Submissions Report

Punchbowl, Affordable Housing, State Significant Development

150 The Boulevard and 34 Dudley Street, Punchbowl

SSD-83256463

2 Ground Floor
1:50

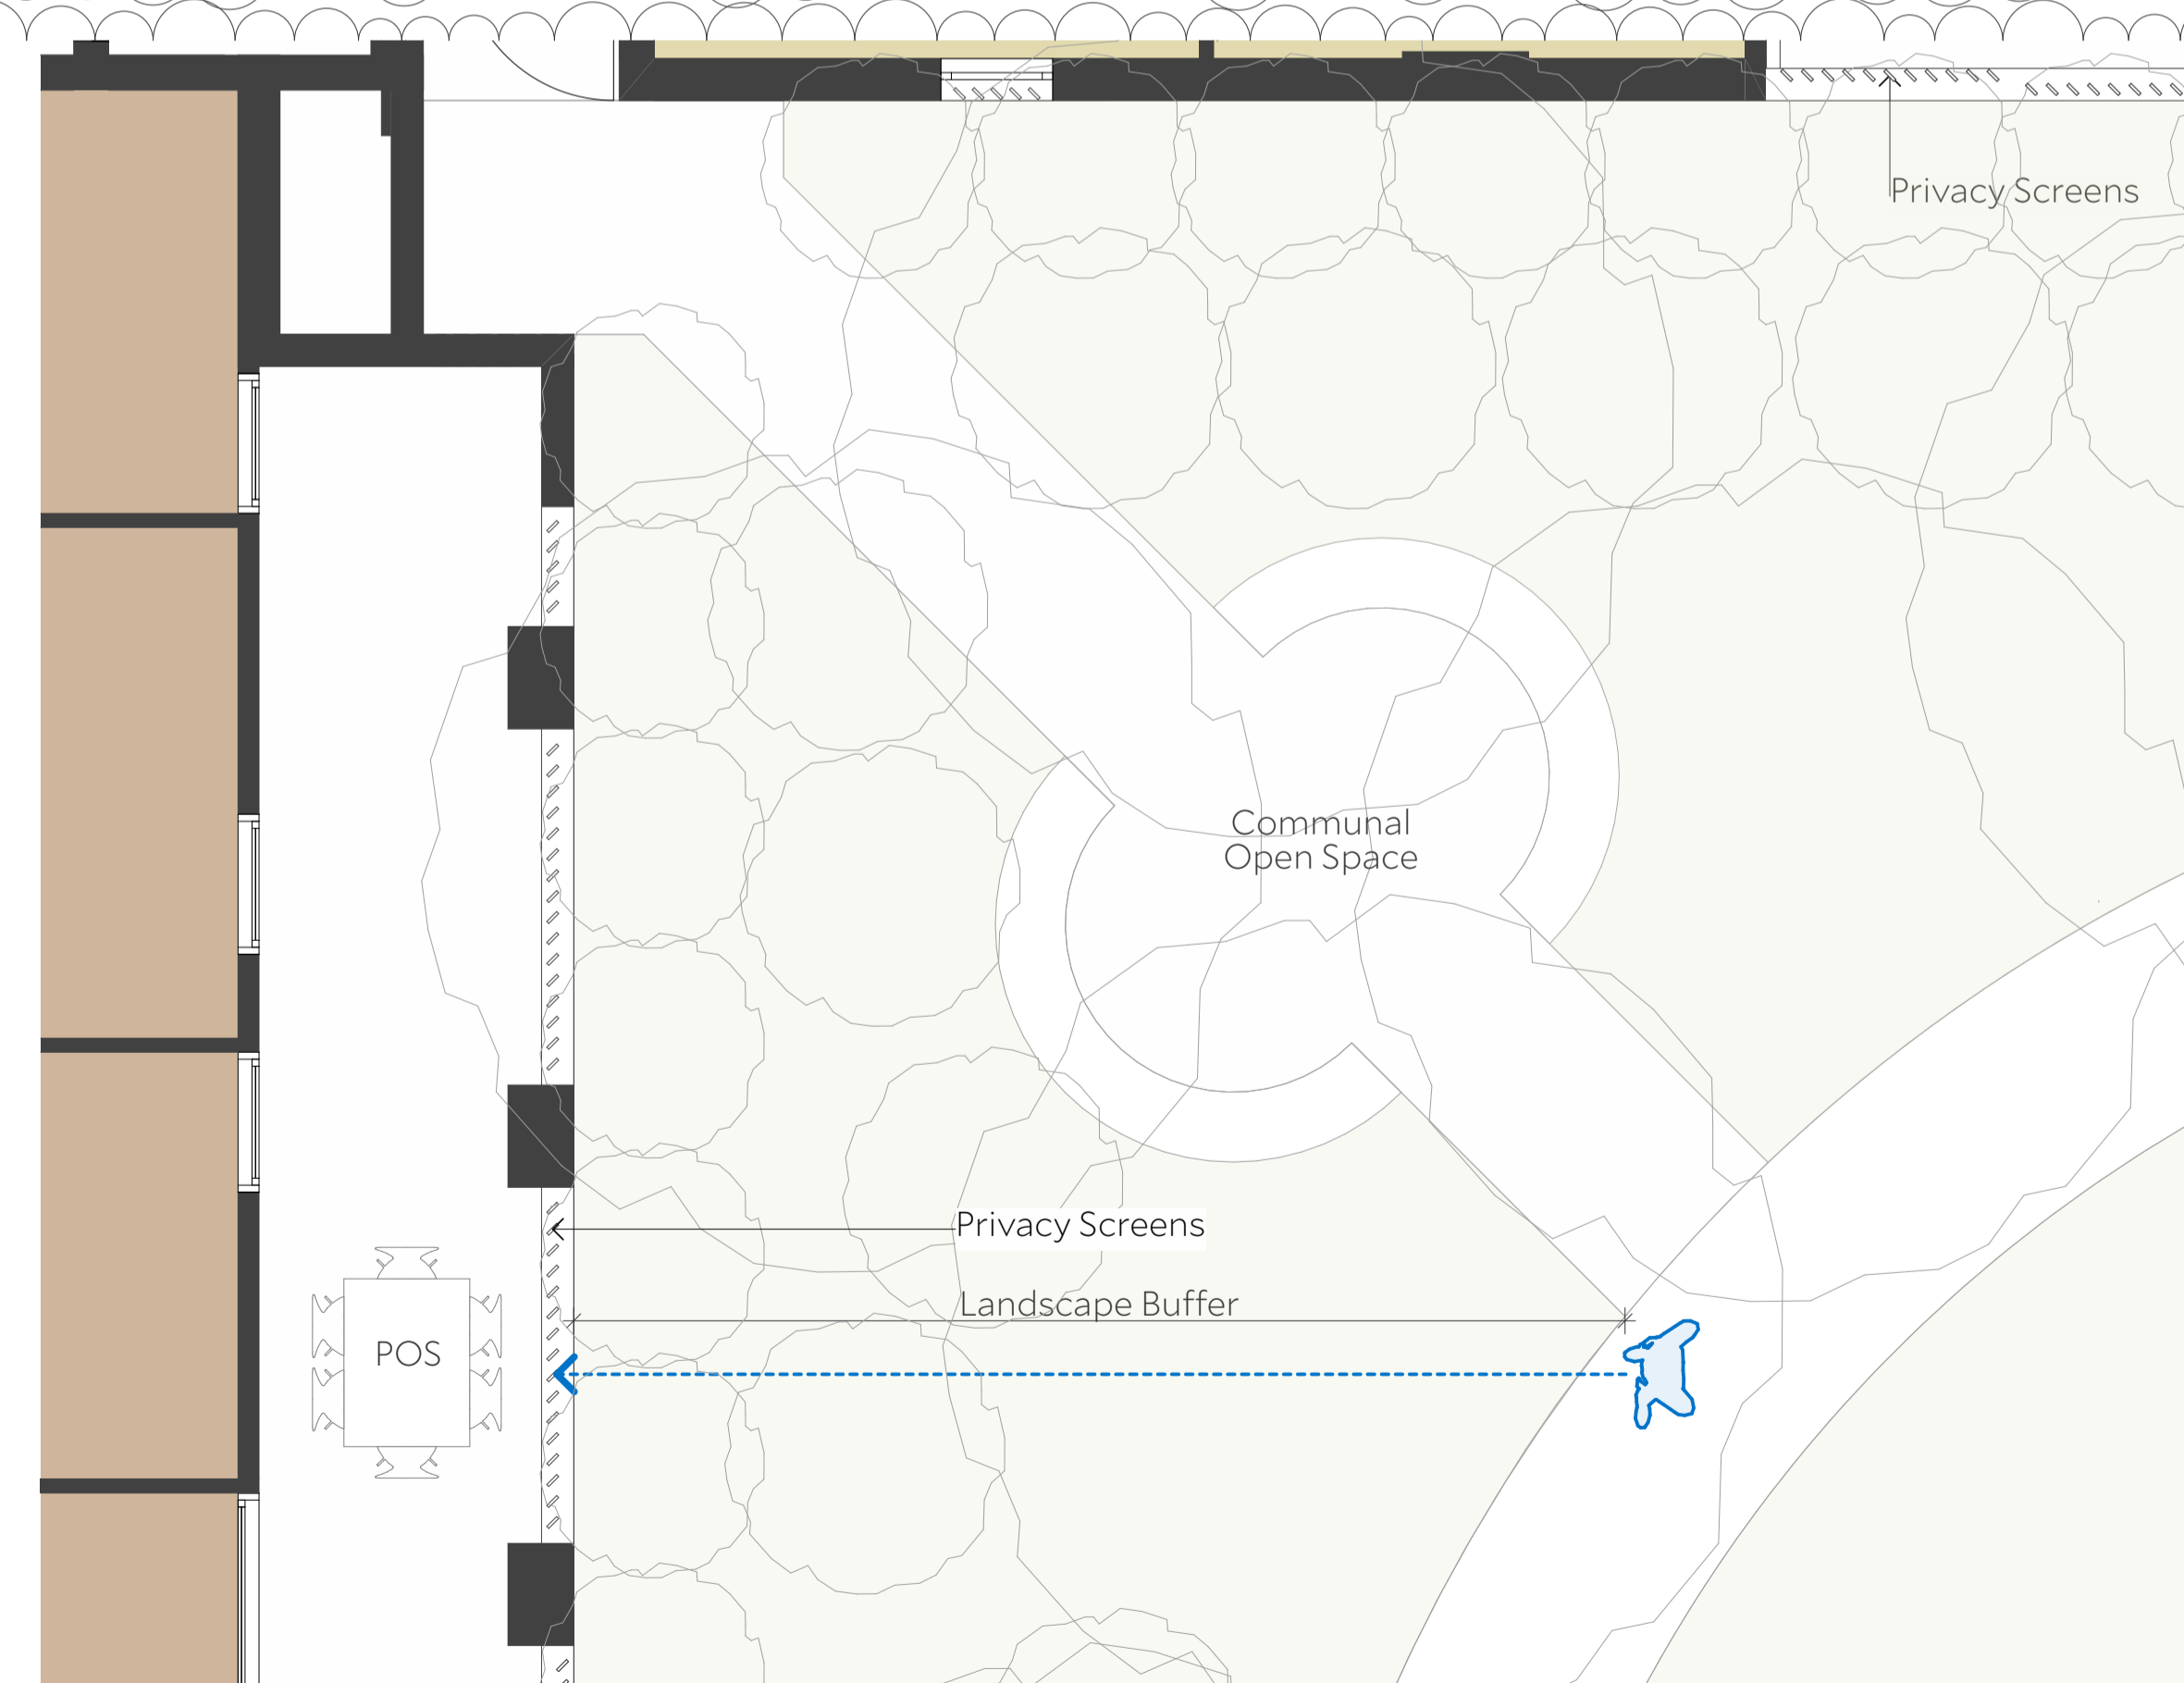
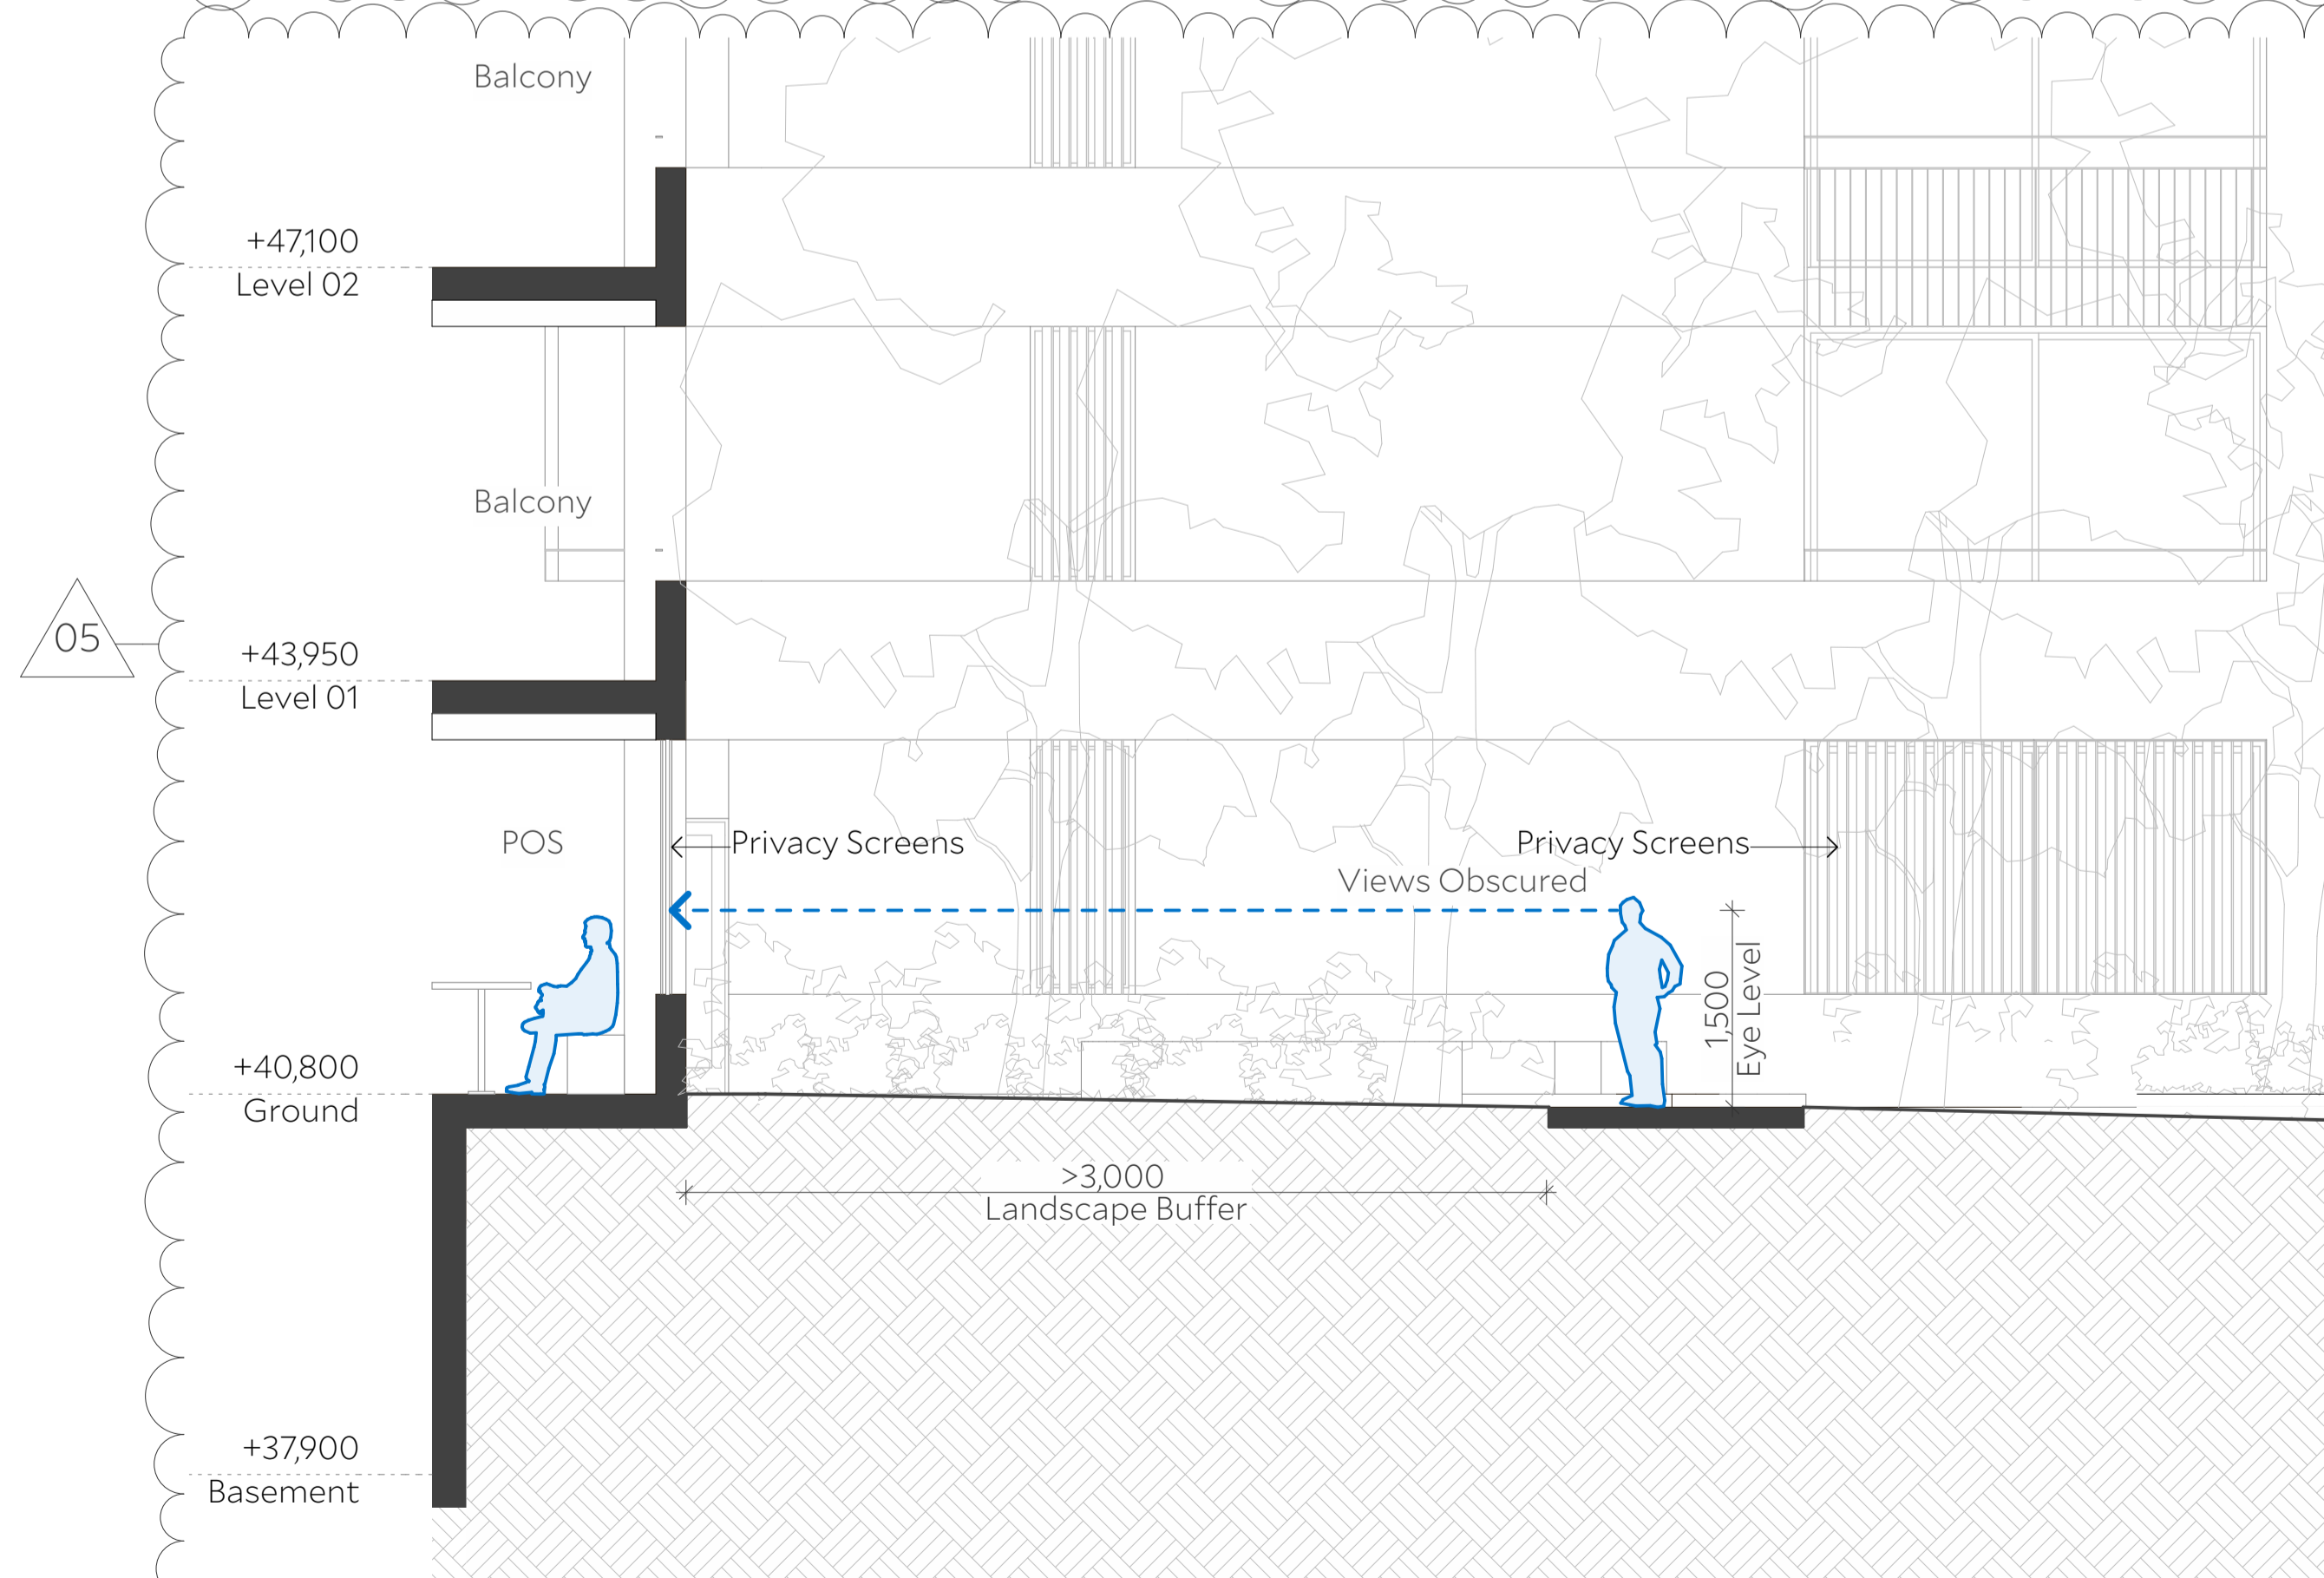
3. Amenity impacts to surrounding properties		
3.1	The finished ground level of the communal open space (RL 40.50-40.70 AHO) may enable overlooking to habitable room windows at No. 149 The Boulevard, which have sill heights of RL 40.80 and RL 41.14 AHO (as per Survey Plan). Mitigation measures must be included to address this potential overlooking. The Department does not support landscaping as a sole mitigation measure for visual privacy.	Additional screening (1.5m) has been integrated into the design of the communal open space as a mitigation measure to minimise the potential for overlooking from the communal open space into habitable rooms of the neighbouring property at 149 The Boulevard. The diagram below shows the proposed screening to minimise overlooking to 149 The Boulevard.  Refer to the Sightline Analysis in the updated Architectural Plans at Appendix B, and updated Landscape Plans at Appendix C for further detail.
